DELEGATED ITEM FILE REPORT - APPROVAL

3/2012/0669/P

Full application for the proposed erection of an industrial unit and alterations to parking provision on land at Lincoln Way, Clitheroe

PROPOSED PLANS, ELEVATIONS AND SITE PLAN

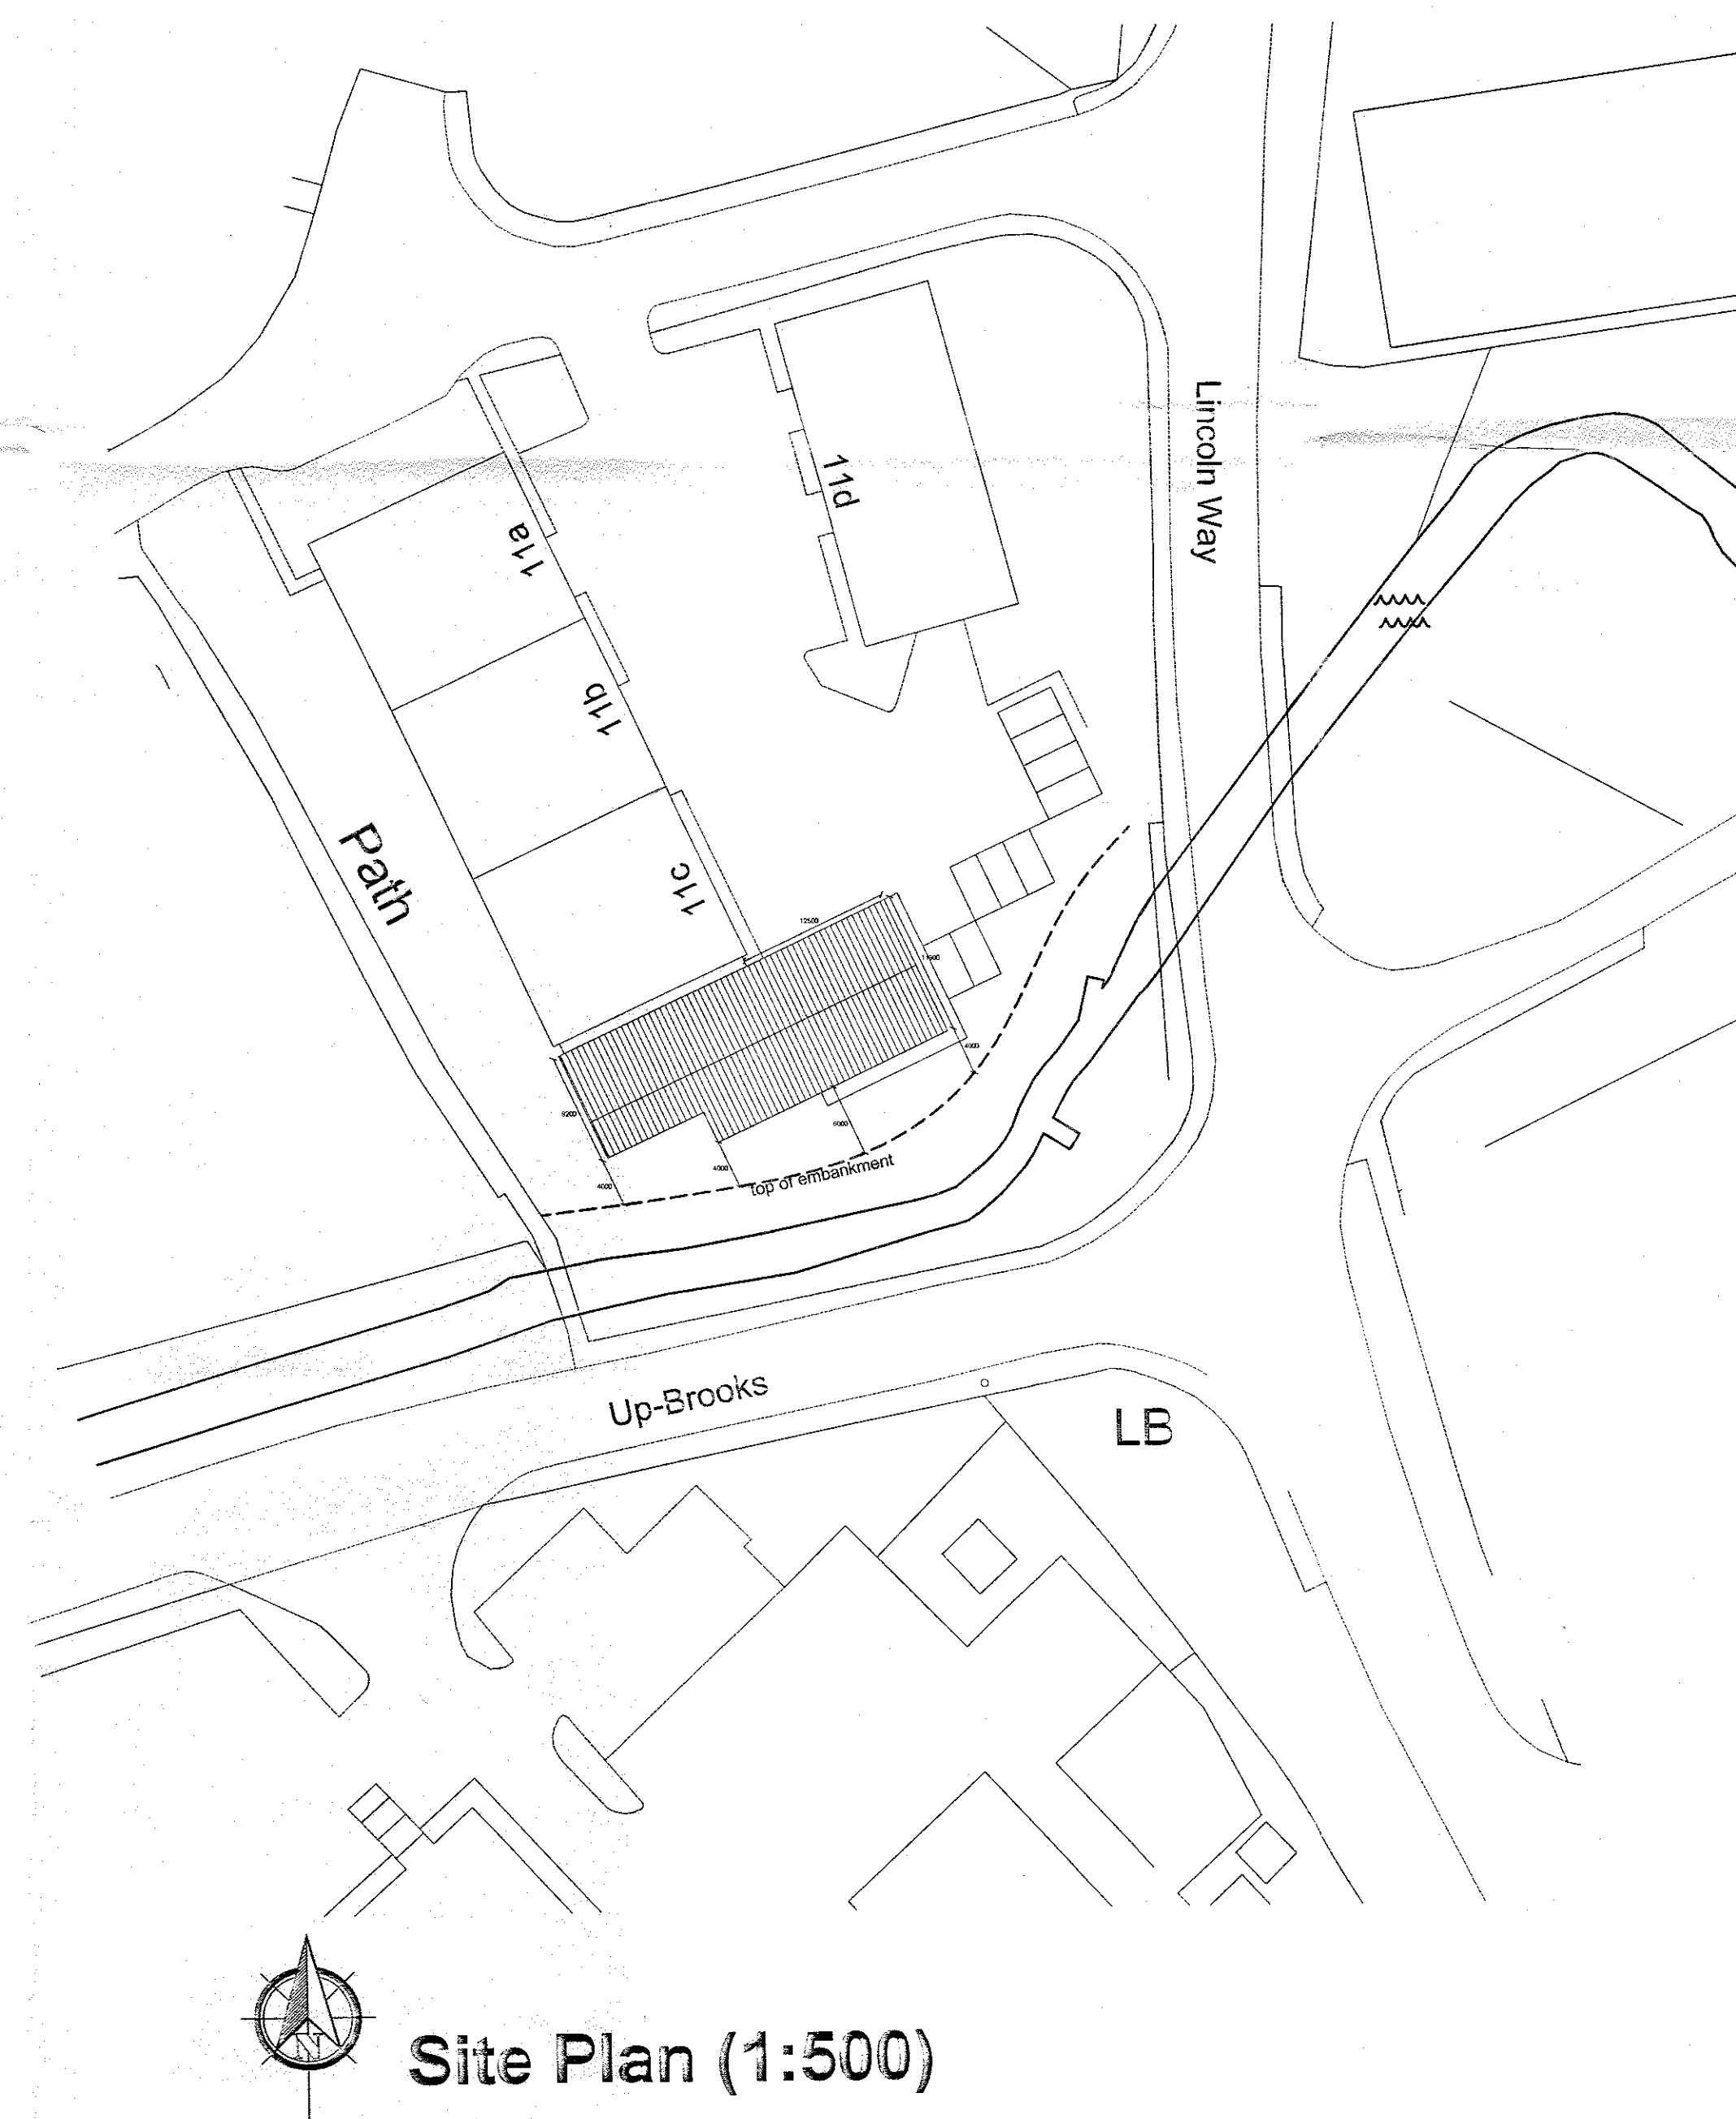
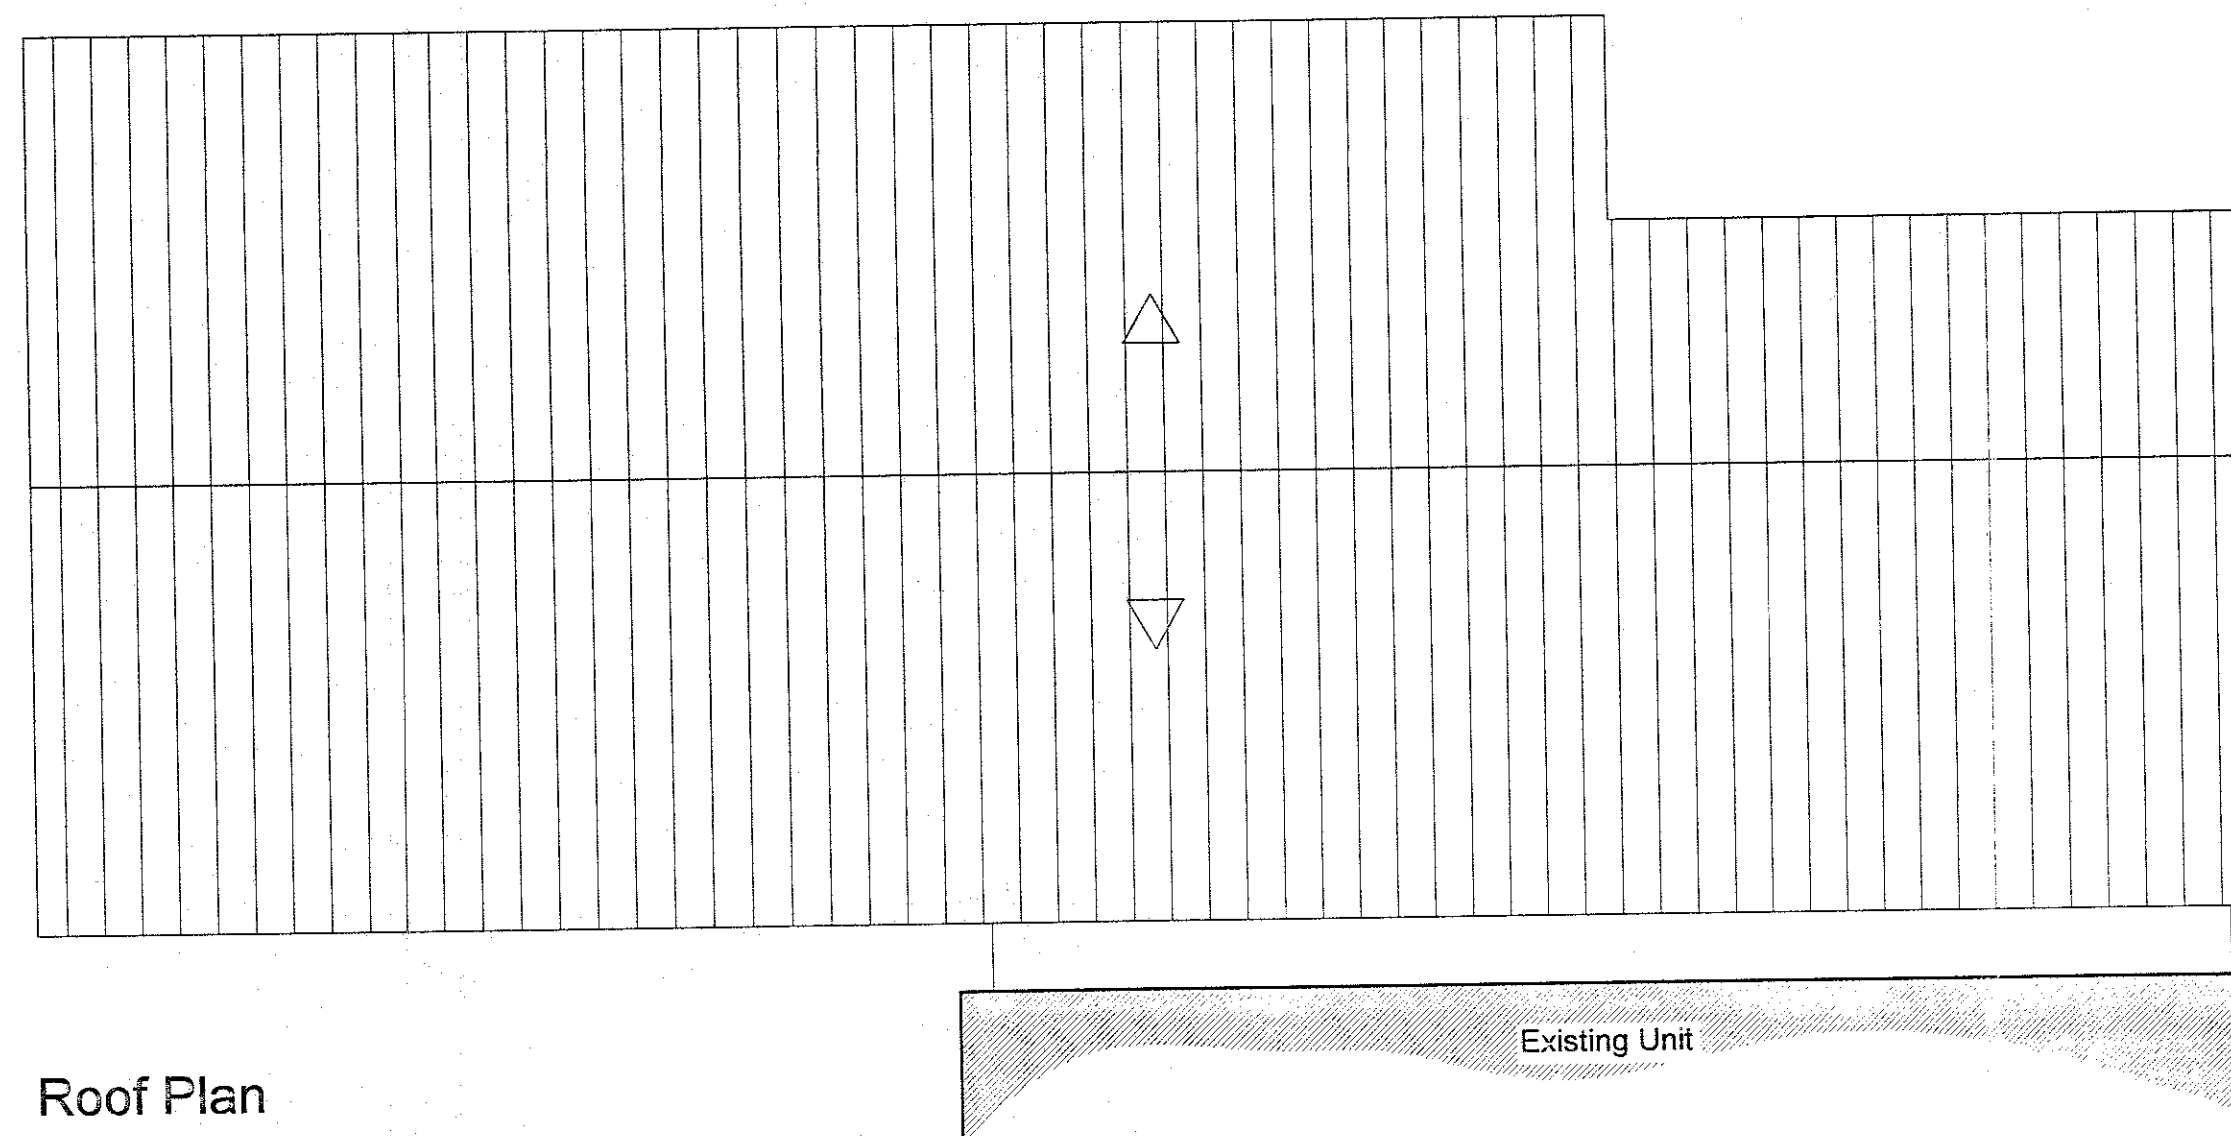
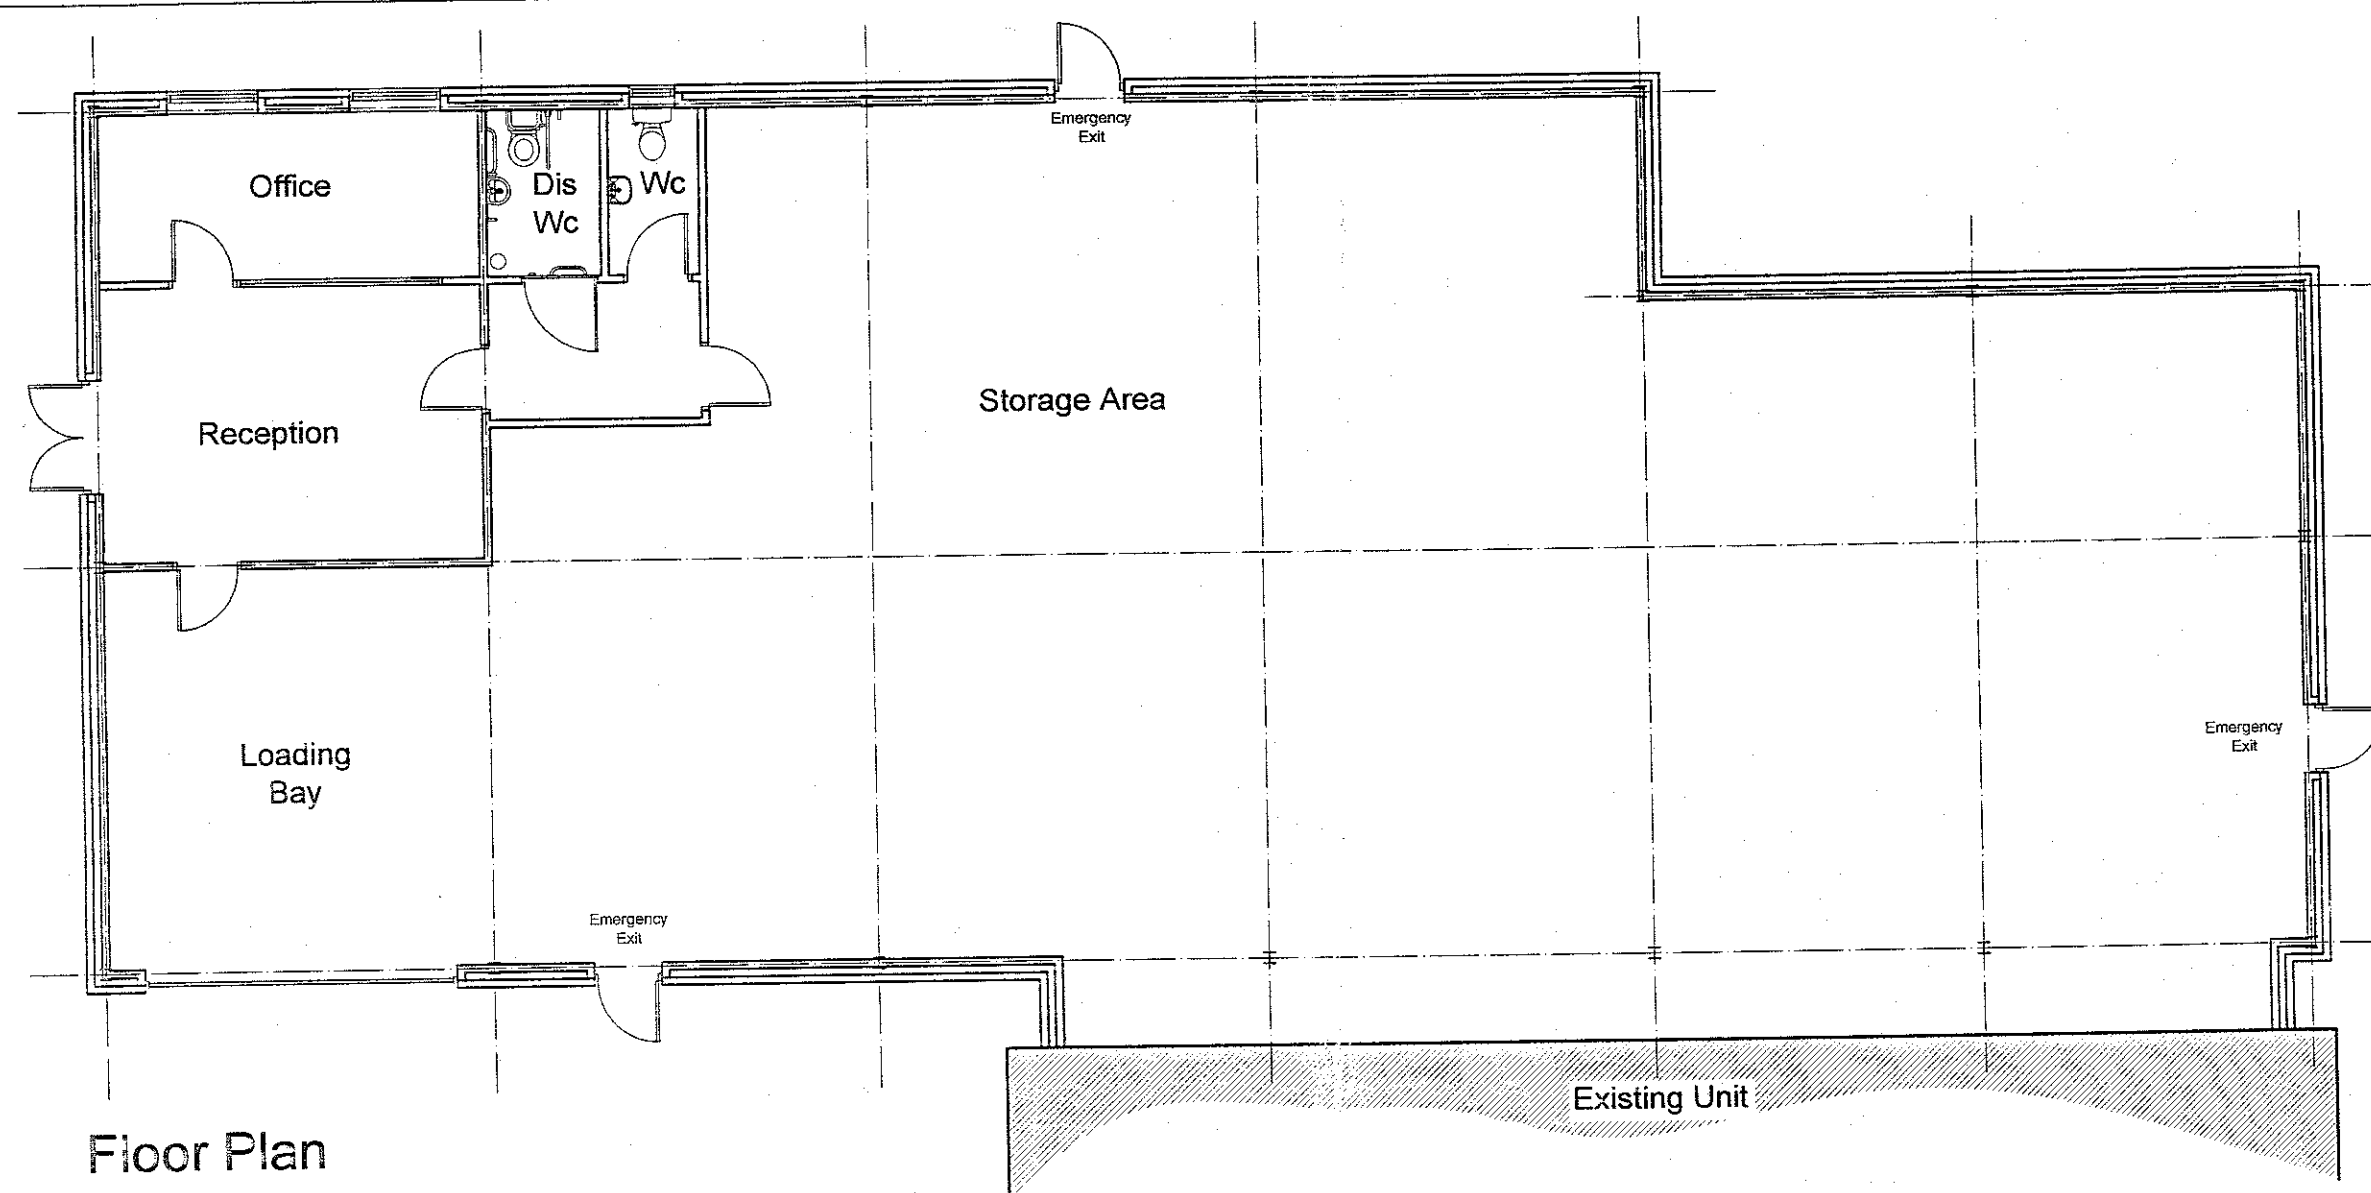
Environment Agency – Originally objected to the application for the reason that the proposed building would be within 8m of the top of the bank of Mearley Brook which is designated a main river. The proposal would therefore be contrary to Land Drainage By-laws. The Agency commented that it would be unlikely to give consent for the development because it would unduly restrict essential maintenance and emergency access to the main river watercourse; and that the permanent retention of a continuous unobstructed area is an essential requirement for the future maintenance and improvement works to this river. The Agency did advise that their objection could be overcome by a revised scheme but that the building should still not significantly encroach within 8m of the top of the riverbank. They recommended that the applicant should contact the Environment Agency to discuss their access requirements and provide revised plans and drawings showing the top of the riverbank and detail how any revised scheme would incorporate their requirements.

By letter dated 10 October 2013, the Environment Agency confirmed their agreement to a 4m wide access strip as shown on the amended plan received 18 September 2013 and confirm that they therefore withdraw their objection to the proposed development. The Environment Agency, however, further explains that, under the terms of the Water Resources Act 1991 and the Land Drainage By-laws, the prior written consent of the Agency is required for any proposed works or structures in, under, or within 8m of the top of the bank of the main river Mearley Brook. Such an application for Flood Defence Consent has been submitted and has been approved.

As originally submitted, the footprint of the building measured 26.6m x 11.5m with a link to the existing building having a footprint of 16.5m x 0.9m, all in accordance with the previously approved scheme. The footprint of the building has been slightly reduced on an amended plan in order to satisfy the requirements of the Environment Agency. The building in the originally approved scheme had a mono-pitched roof but, in this current application, the building has a traditional ridged roof with an overall height of 6.8m and an eaves height of 5.5m. This is considered to represent an improvement in visual terms on the originally approved roof design.

Notwithstanding that the size and location of the building was the same as previously granted by the outline permission, the Environment Agency originally expressed an objection to the application. As stated above, however, through negotiations with the Environment Agency, the shape of the building has been amended in order to provide a clearance to the bank top of Mearley Brook that is now to the satisfaction of the Environment Agency. That initial objection to the proposed development is therefore now overcome.
